**Re: Kairos Power Phase 3 – 5102 Hawking Dr. SE
Erosion and Sediment Control Plan Q16E5000D
Engineer's Stamp Date (2/18/25) SWQ-2025-00011**

Based on the information in your submittal received on 5/8/25, the above-referenced ESC Plan cannot be approved until the following comments have been addressed.

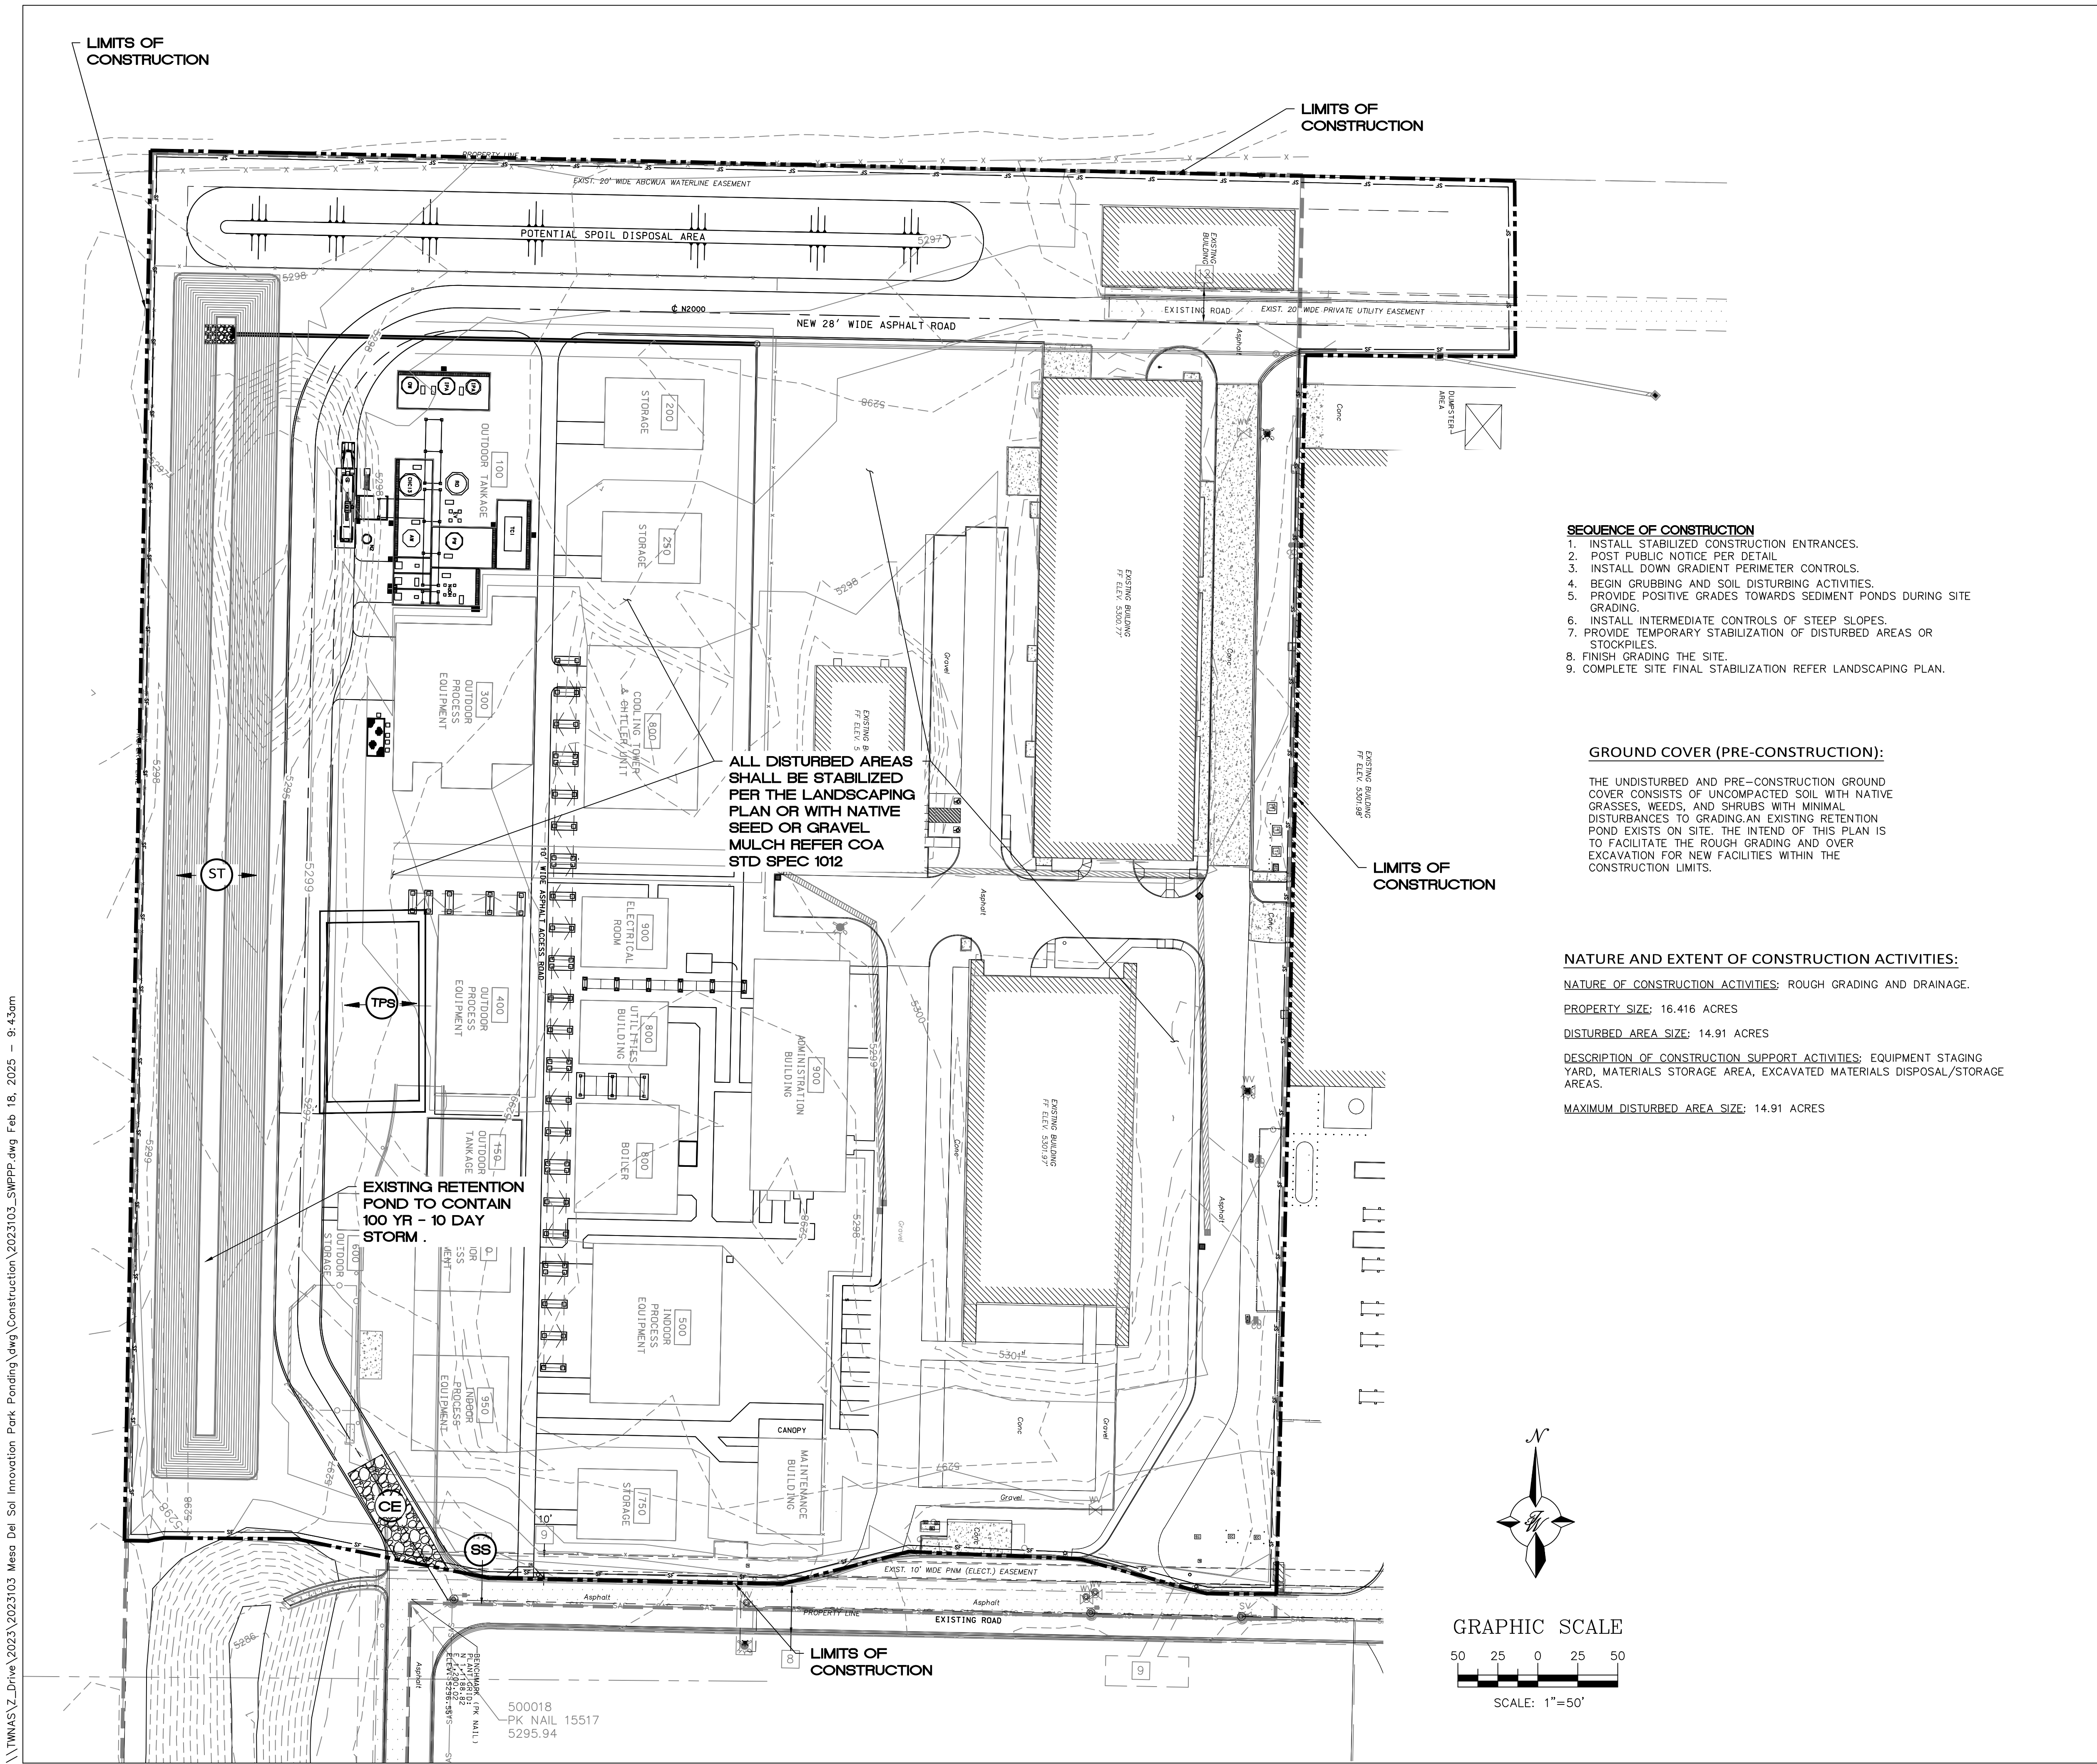
1. The existing and proposed contours, location of structures, other impervious surfaces, and storm drains must be shown on the ESC Plan, and they must agree with the G&D Plan approved by Hydrology, per the EPA's CGP 7.2.4 and the city's ESC Plan Checklist (attached). This information is missing and inaccurate on the ESC Plan and must be revised and resubmitted to ABQ-PLAN.
2. Precautions must be added to the ESC Plan to prevent the discharge of stormwater north into adjacent property during construction. Since the G&D Plan shows a proposed swale draining most of this site to the north and a ridge between the swale and the west pond, additional downgradient controls are needed along the north limits of land disturbing activities, such as a temporary diversion berm with a minimum top elevation of 5299 or higher.

You submitted the same ESC Plan this time as you did in February, despite significant changes being made to the G&D Plan since the February submittal. You will need to resubmit a revised ESC Plan using the same SWQ-2025-00011, incorporating the information from the detailed G&D Plan approved by Hydrology. If you have any questions, contact me at 924-3420 or jhughes@cabq.gov.
